**WEST SUSSEX COUNTY COUNCIL
INFRASTRUCTURE CONSULTATION**

**SUBJECT: BR/161/11/A - Proposed non-illuminated signage to Click & Collect facility
including additional freestanding directional signage.**

Tesco Stores Ltd, Shripney Road, Bognor Regis, West Sussex, PO22 9ND

Drawing Number: **2011(2102)/P/22** Rev.: **A**

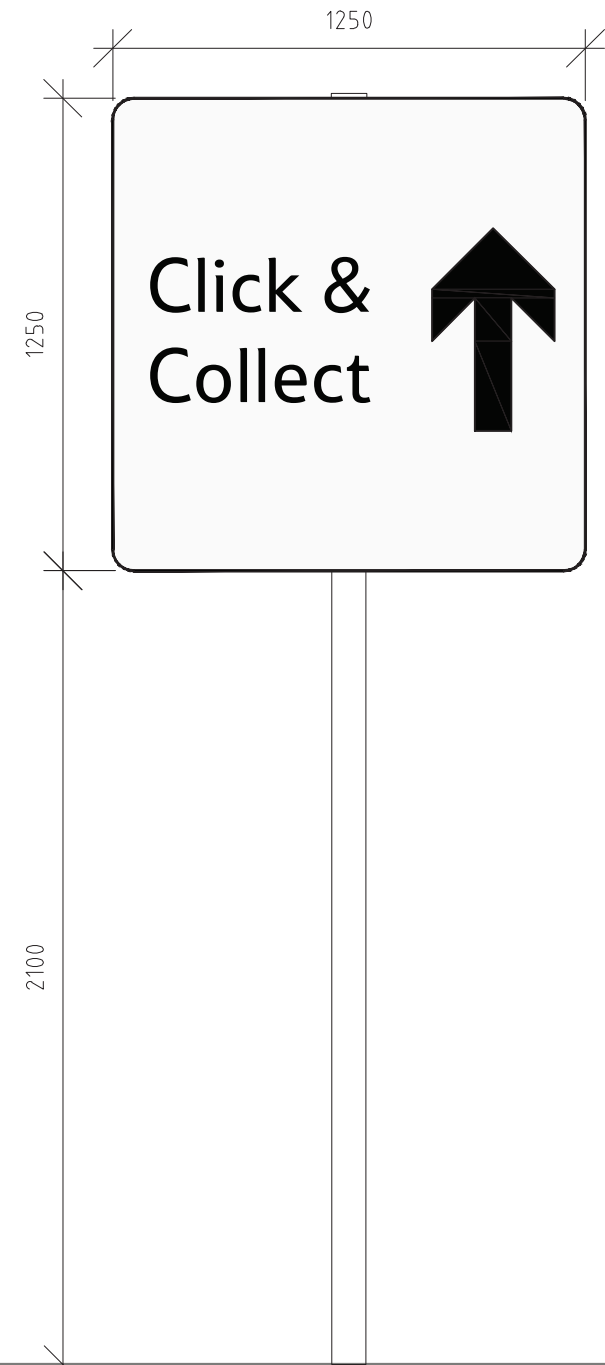
Upon inspection of the plans, it does not appear that these signs are in a location where they could obstruct the highway.

In conclusion, there are no highway concerns associated with this proposal.
